**Waynflete Modular SP# 2017-0046 PFD comments.pdf**
7K

From: Kelley, Mark
Sent: Monday, June 19, 2017 3:28 PM
To: 'Julia Tate'; Briere, William R.
Subject: RE: 17 Fletcher St., BP# 2017-00673 Waynflete Modulars

4 FOOTINGS DETAIL

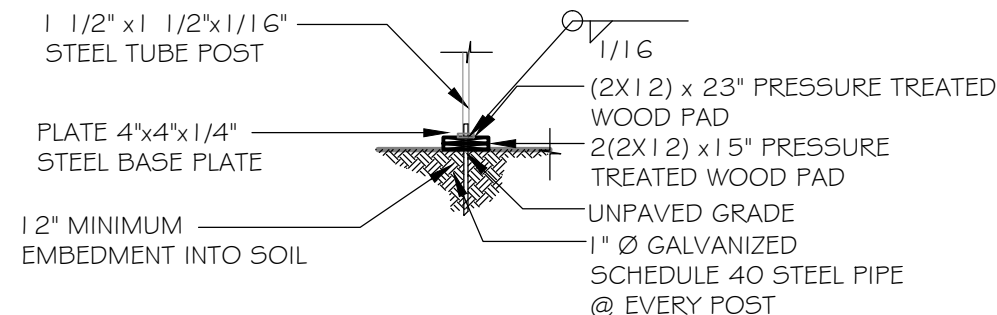
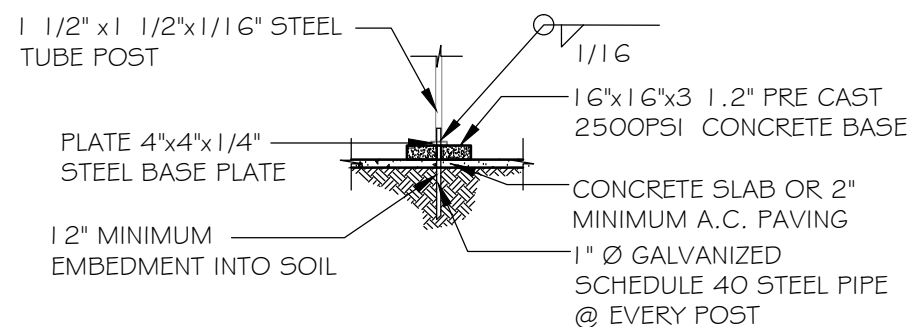
We have also heard back from Williams Scotsman on the foundation (the project manager is back this week) - please see below:

Given that the modulares are temporarily installed, they do not provide full foundations or frost protection. The single wide unit will be placed on the same concrete block/abs setup as the double wides as follows:

"Our foundational block is ground level, 3 cell concrete blocks(no mortar) placed on top of ABS pads. There are no sub frost(or any subgrade) footings. Also ramps do not have frost protection or footings either. They sit on aluminum feet on ground level."
